22 February 2013

Preferred Project Report for Concept Plan MP08_0207 & Project Application MP10_0219 – Home Units Development at 1, 1A & 5 Avon Road and 4 & 8 Beechworth Road, Pymble

FIGURE 30 – SECTION THROUGH BUILDING 3 AND 15 AVON ROAD

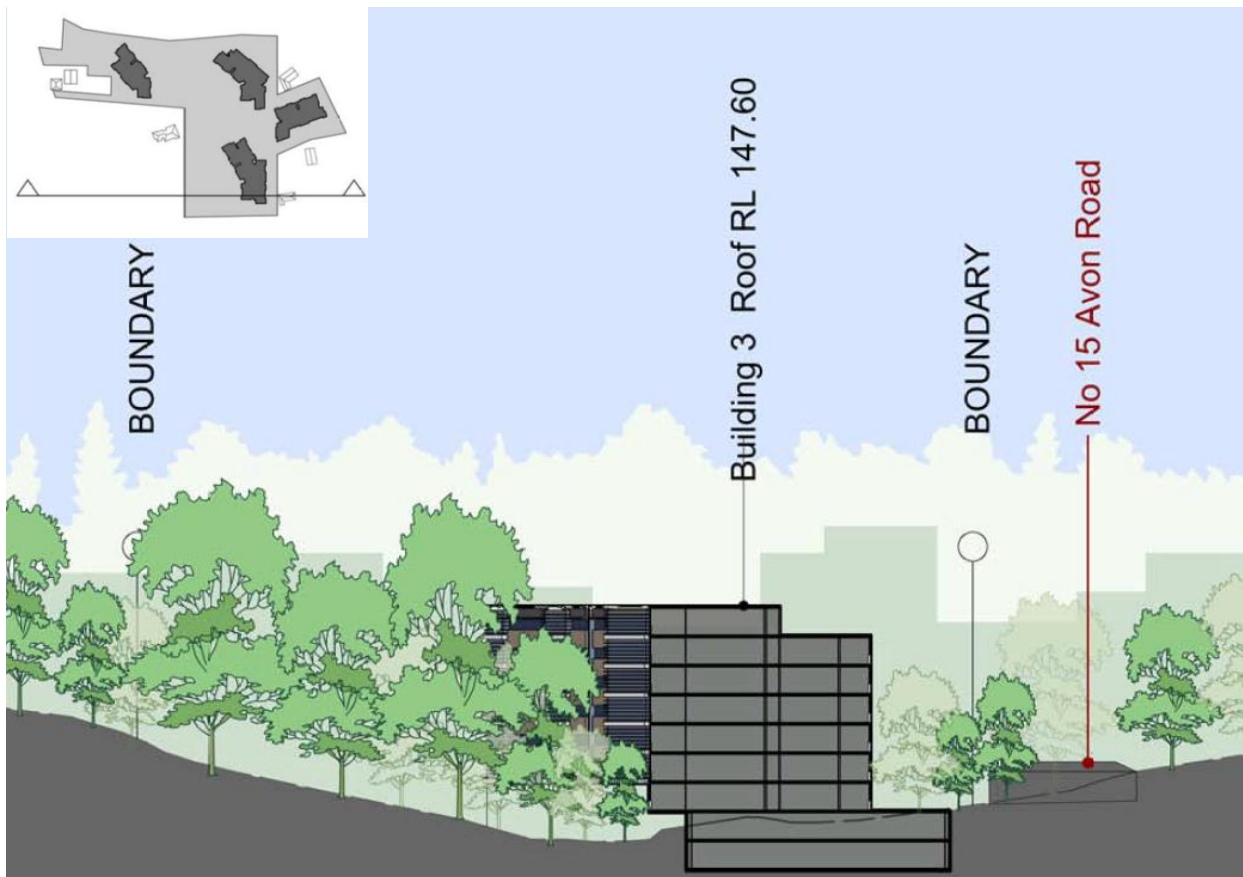
Also, Building No. 3 is only 11.5 metres from the house at 15 Avon Road (Map 02.03 Appendix F). Section 3 of 02.07 Appendix F shows Building No. 3 is 4 storeys over the roof of 15 Avon Road: $144.6 - 134 = 9.4$ metres. Building No. 3 is also higher than the roof of 11 Avon Road ($144.6 - 139 = 5.6$ metres).

The PPRR also requires that Building No. 1 be reduced in bulk and scale to reduce its impact. However, it is little altered and remains too high and bulky to Avon Road. In addition it is 8.47 metres over the roof line of 7 Avon Road (Figure 31 in PPR) at a distance of 10.3 metres from the boundary of 7 Avon Road. Furthermore, it is unclear whether the one significant tree towards the rear of 5 Avon Road on its boundary is to be retained (the other large tree within the boundary of 5 Avon Road is dead).
